COMPREHENSIVE OBJECTION TO AMENDED STATE SIGNIFICANT DEVELOPMENT APPLICATION

**SSD-83478456 — Residential Development with In-fill Affordable Housing
21, 23 and 25 McIntosh Street and 55 Werona Avenue, Gordon**

Date: 9 June 2026

Submitter: Owner of 12 Forsyth Street, Killara/Gordon (this submission updates earlier submission ref: SUB-92392706).

PROJECT	McIntosh and Werona Ave Residential Development	SHEET	Roof Plan
CLIENT	CPDM Development Partnership & Management	PROJECT NO.	3303
PROJECT ADDRESS	23-25 McIntosh S. & 55 Werona Ave Gordon, NSW 2072	SCALE	1:200@A1
		SHEET NO.	DA10.10
		REV	B

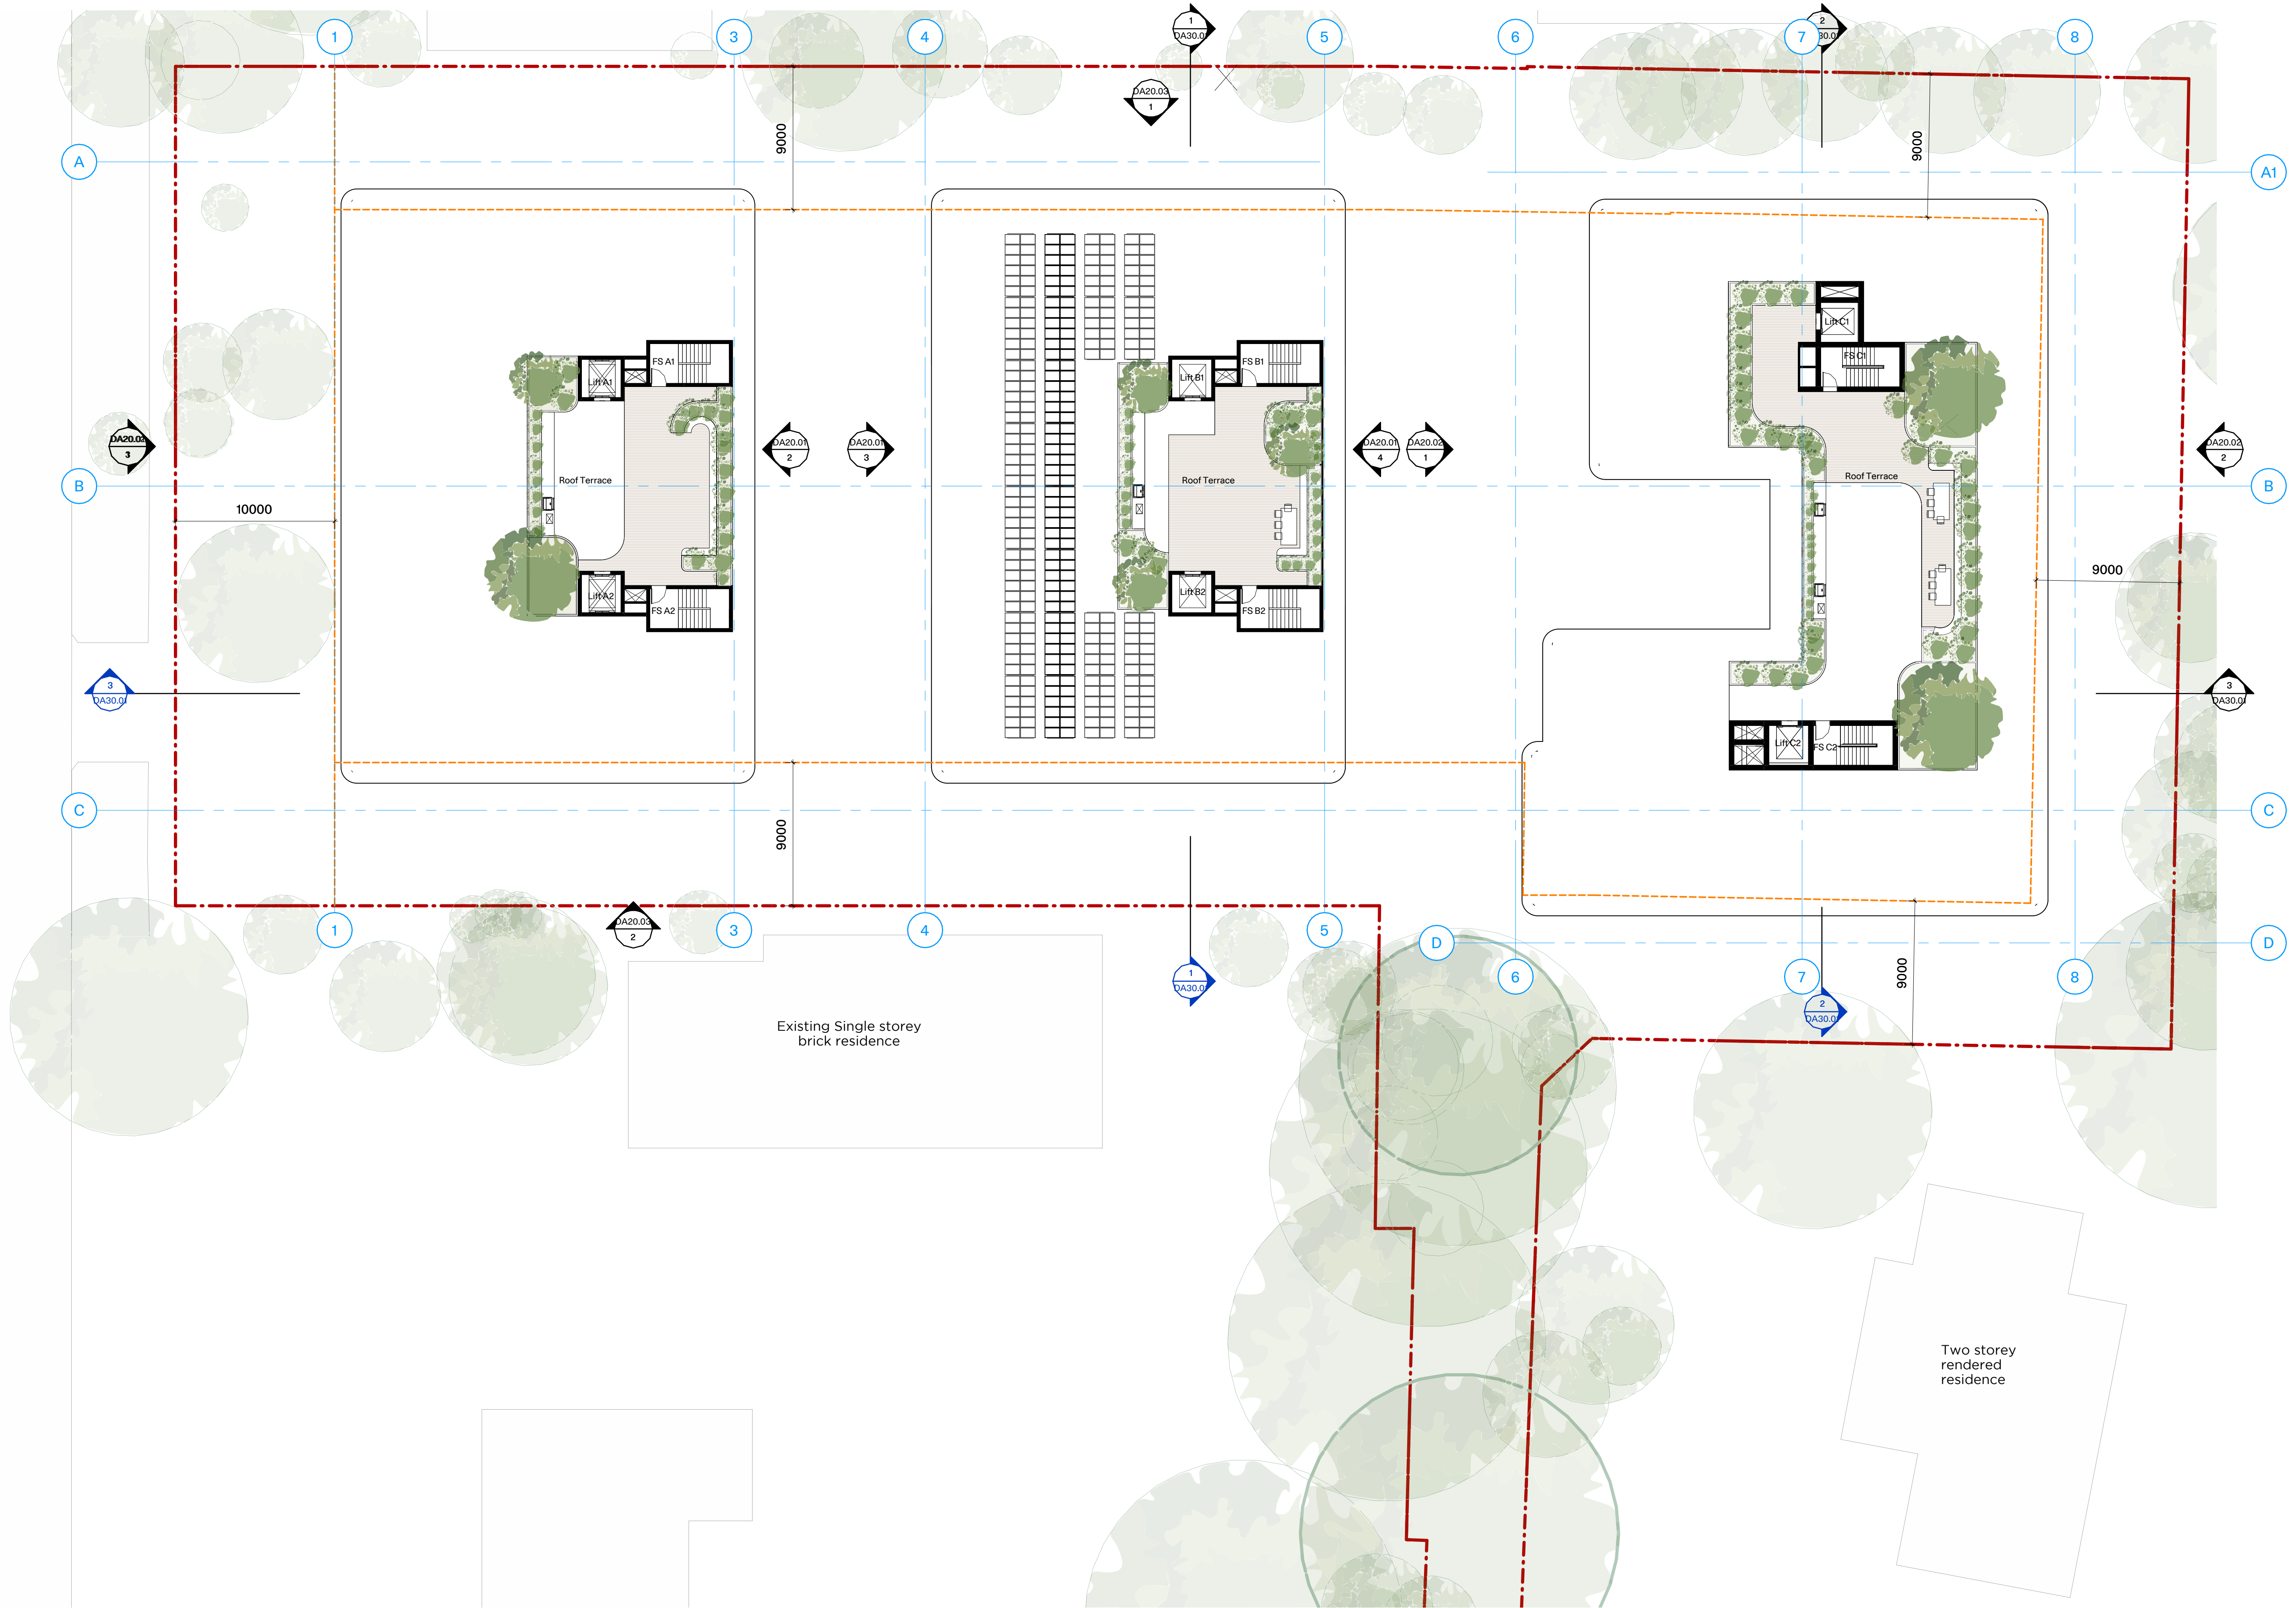
The applicant's own documents identify Building C as the direct southern interface. It is not a minor roof form: the plans and reports identify Level 8 / roof-level residential and communal open space, and landscape drawings show active rooftop elements including BBQ, seating, decking and balustrades.

The Building C rooftop communal open space should be deleted or relocated. If retained, it must be subject to fixed privacy treatment, solid balustrades, acoustic barriers, low-glare lighting, strict hours, no amplified sound, no BBQ after evening hours, and enforceable strata by-laws. My primary position is that these measures are inferior to built-form reduction and relocation.
